Project Name	Complete 540 - TIP R-2721B		Date	Initial
Deliverable Type/Name	R-2721B Permit Drawings Review (S-012)		8/2/2019

**BUFFER DRAWING
SHEET 10 OF 19**

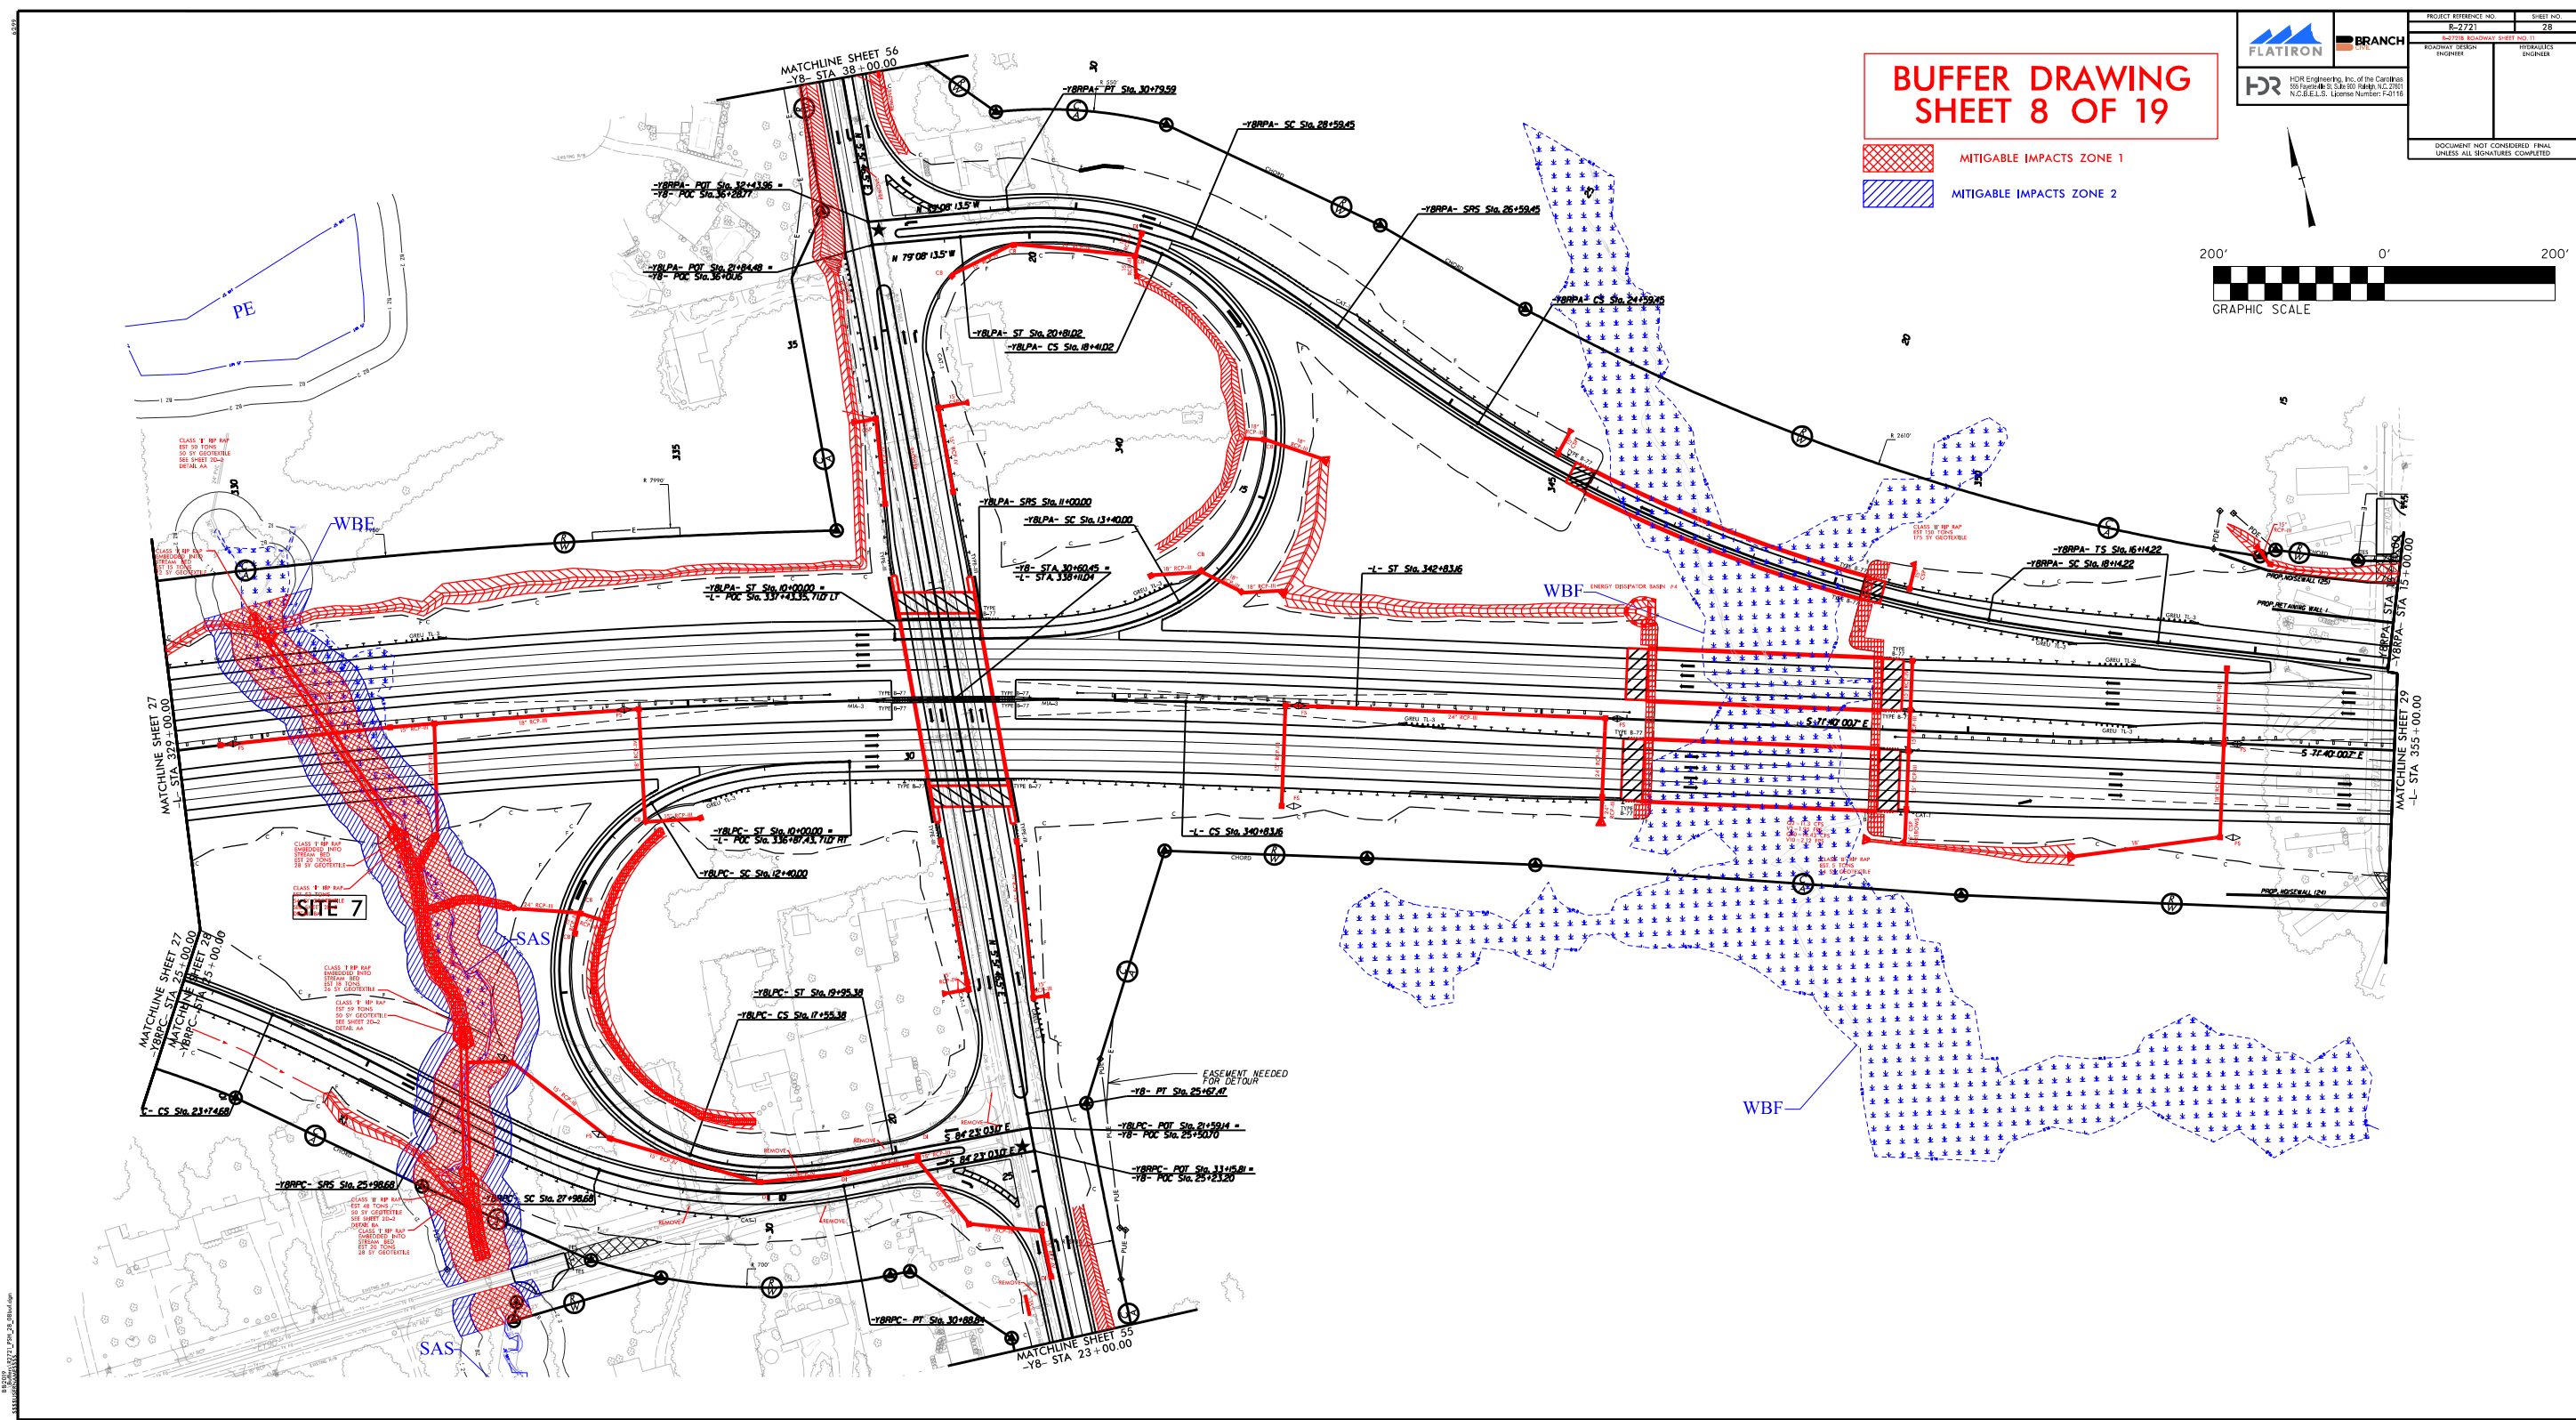
124	General	ALL	HWM/NJT/MW	Where pond buffers extend beyond the ROW, the plans currently show impacts to the entire buffer; however, the callout label states they are only shown to ROW but calculated in their entirety. Please adjust so the impacts are shown correctly	Updated		
125	Buffer drawing 4 of 19	24	HWM/NJT/MW	Utility impacts were originally proposed along stream SAM; account for buffer impacts appropriately and include a PUE where needed	Sewer line crosses NCDOT ROW at this location. Please refer to utility plans.		
126	Buffer drawing 4 of 19	24	HWM/NJT/MW	Buffer impacts extend beyond wetland impacts on south side; adjust so they match	Updated		
127	Buffer drawing 4 of 19	24	HWM/NJT/MW	Where is Buffer plan sheet 8? Rip rap pad in buffer at STA 295+00	Included		
128	Buffer drawing 10 of 19	31	HWM/NJT/MW	Label inset	Updated		
129	Buffer drawing 10 of 19	31	HWM/NJT/MW	In inset, adjust buffer hatching color to match plan sheet	Updated

130	Buffer drawing 10 of 19	31	HWM/NJT/MW	In inset, add wetland symbology to wetland pocket	Updated		
131	Buffer drawing 10 of 19	31	HWM/NJT/MW	Why did buffer hatching change over near WBJ?	It was two different cells. This has been updated.		
132	Buffer drawing 10 of 19	31	HWM/NJT/MW	Wetland impacts are shown below toe protection at Site 11 (Stream SAX); this will also be buffer impact	Updated		
133	Buffer drawing 10 of 19	31	HWM/NJT/MW	Buffer impact shown below EDB (Site 12) will more than likely be "mitigable" rather than "allowable"	We do not anticipate impacts at this location. Matches previously submitted permit drawings.		
134	Buffer drawing 11 of 19	33	HWM/NJT/MW	Are streams SAZ, SBC or SBC buffered?	They are buffered streams. The drawing match what was provided in the original permit drawings.

BUFFER DRAWING SHEET 14 OF 19

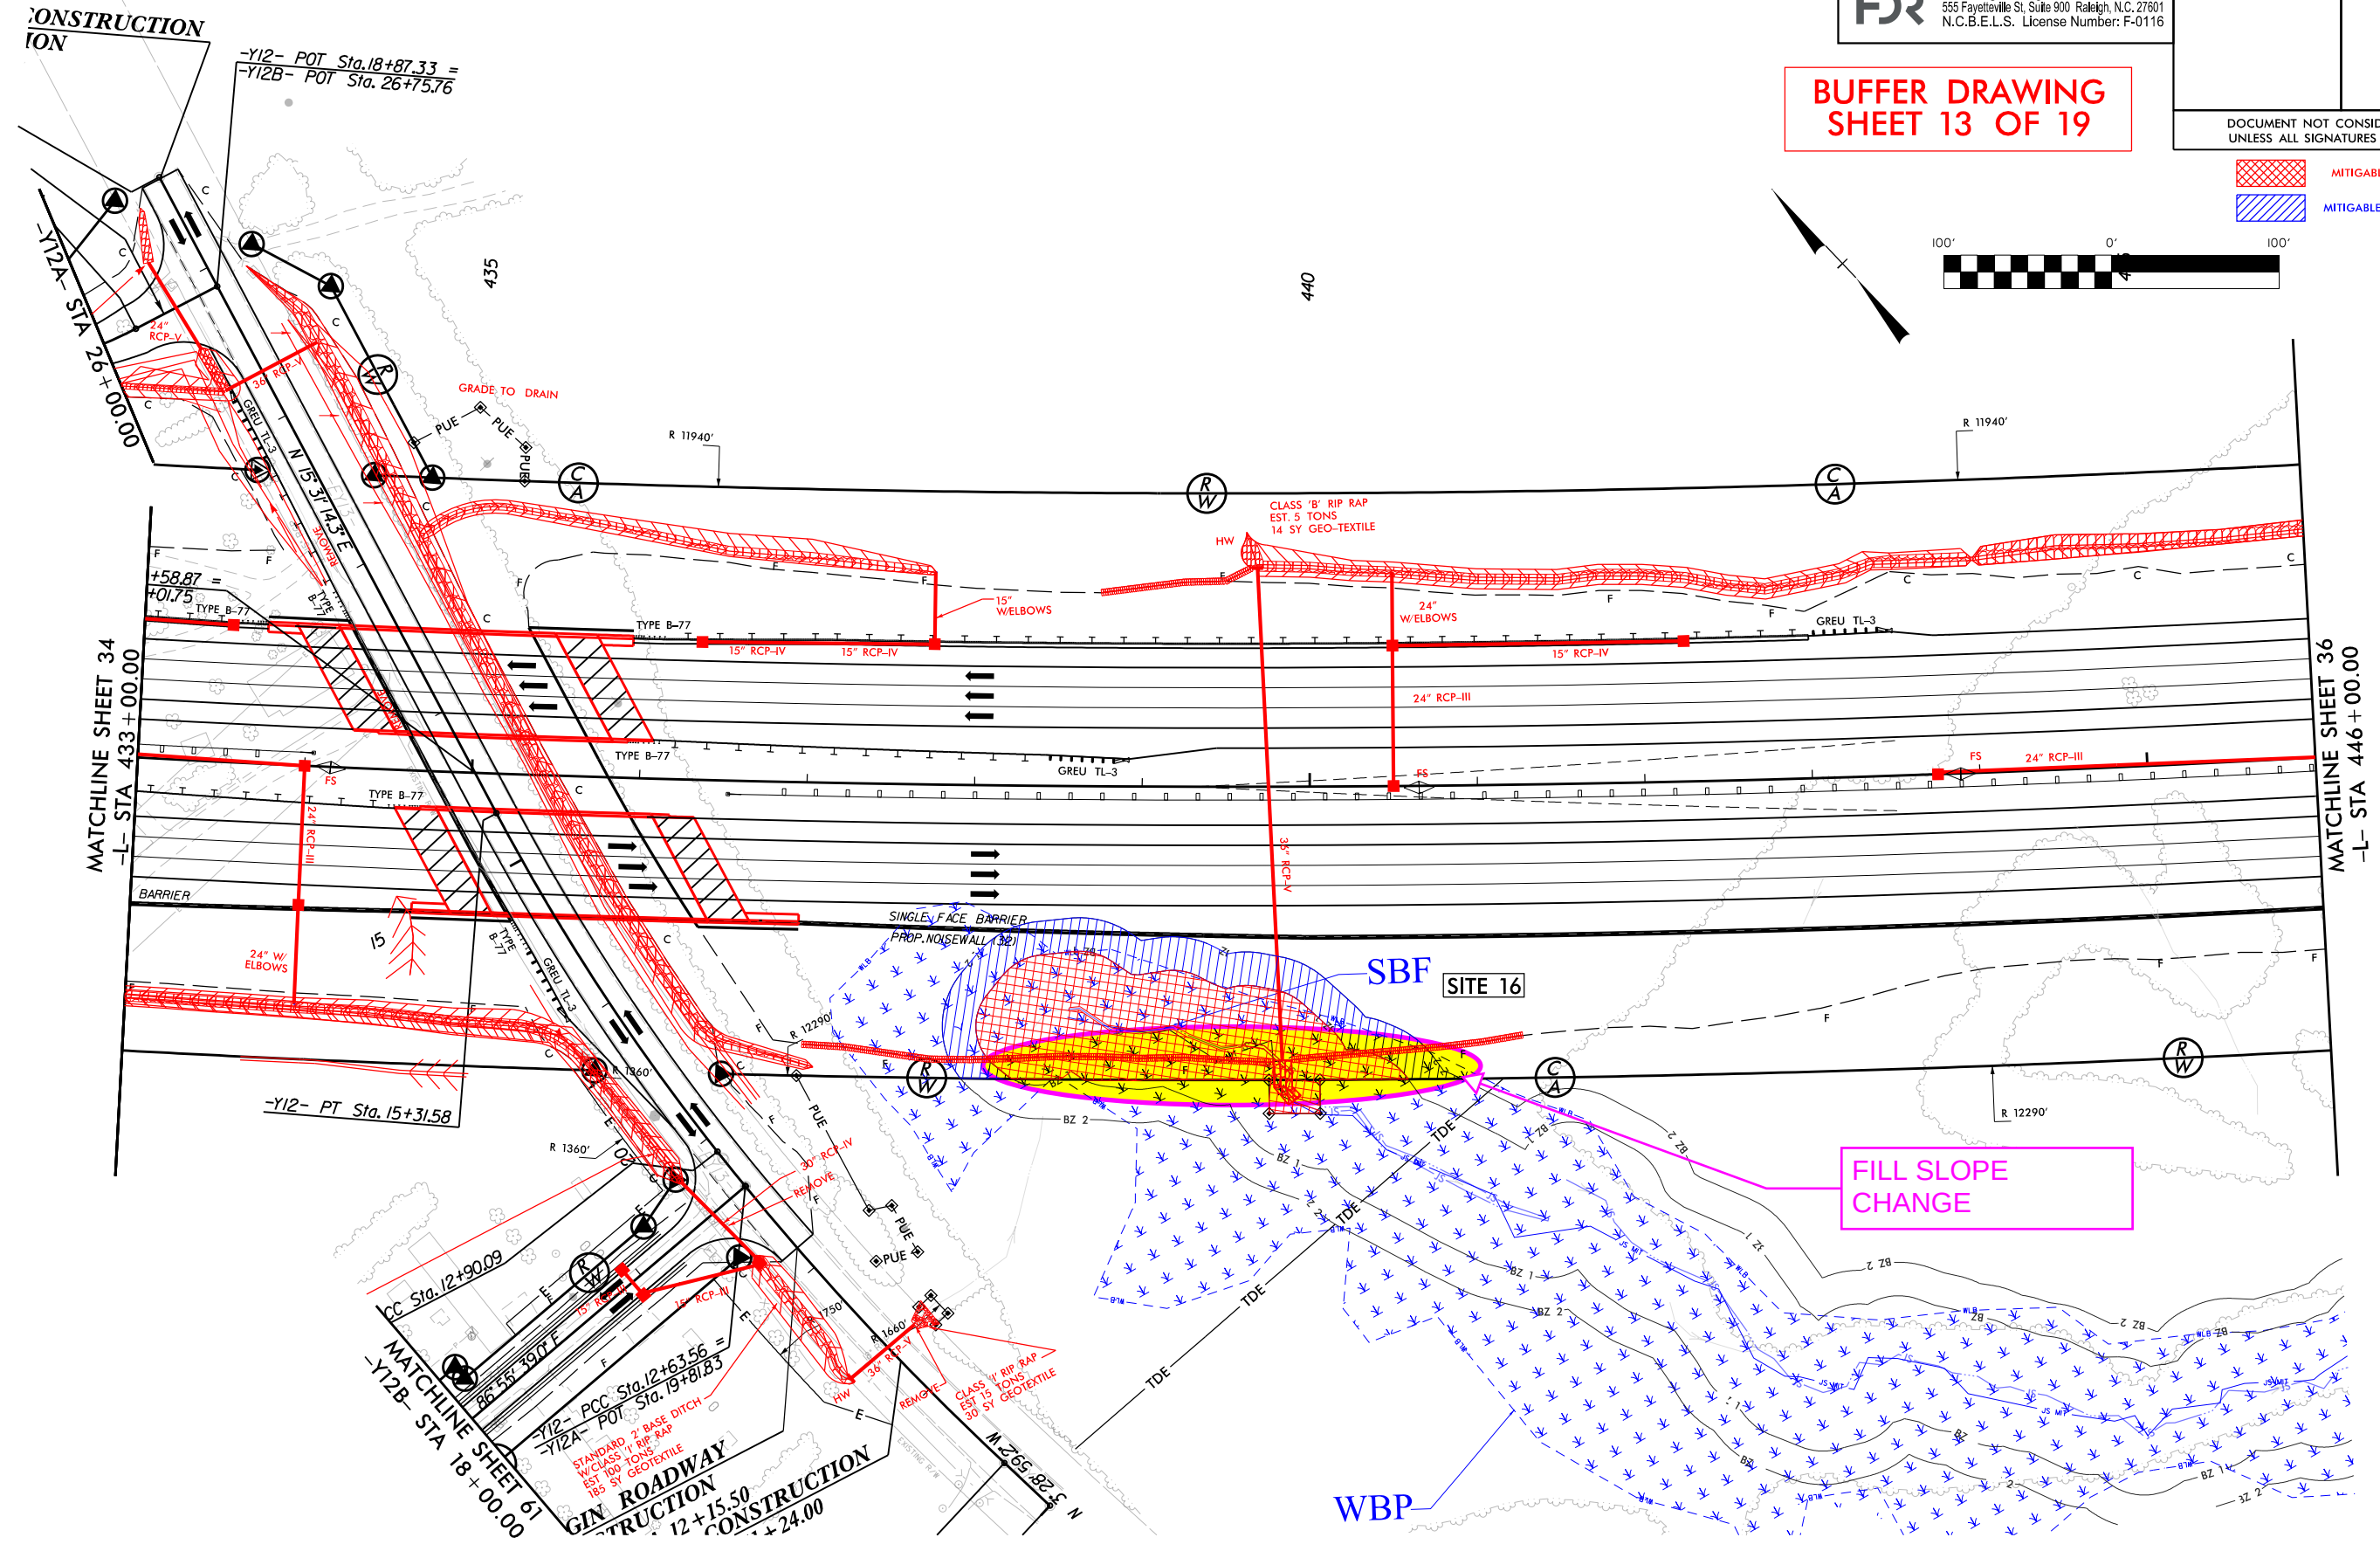
135	Buffer drawing 11 of 19	33	HWM/NJT/MW	extend ditches to rip rap pads at -Y12B-	Roadway ditches already drain to riprap pads; no special cut ditch is required.		
136	Buffer drawing 11 of 19	33	HWM/NJT/MW	Carry buffer impacts for Site 15 to TDE	Updated		
137	Buffer drawing 11 of 19	33	HWM/NJT/MW	What is TDE for at Site 15?	Noted. To be discussed with the Turnpike.		
138	Buffer drawing 11 of 19	33	HWM/NJT/MW	Buffer impacts extend beyond wetland impacts on south side; adjust so they match	Updated		
139	Buffer drawing 13 of 19	35	HWM/NJT/MW	Buffer impacts at Site 16 extend beyond ROW; please adjust	Updated		
140	Buffer drawing 13 of 19	35	HWM/NJT/MW	Impacts at Site 16 are not depicted the same on the Wetland sheets; please adjust so they match	Updated		
141	Buffer drawing 14 of 19	37	HWM/NJT/MW	Need easement around Pond	Noted. To be discussed with the Turnpike.		
142	Buffer drawing 14 of 19	37	HWM/NJT/MW	Label Pond	Updated

143	Buffer drawing 14 of 19	37	HWM/NJT/MW	Why is there a gap in buffer impacts south side of the road?	Bank stabilizarion		
144	Buffer drawing 14 of 19	37	HWM/NJT/MW	Site 16 is listed here again; that was the previous impact.	Updated		
145	Buffer drawing 15 of 19	37A	HWM/NJT/MW	Need easement around Pond	Noted. To be discussed with the Turnpike.
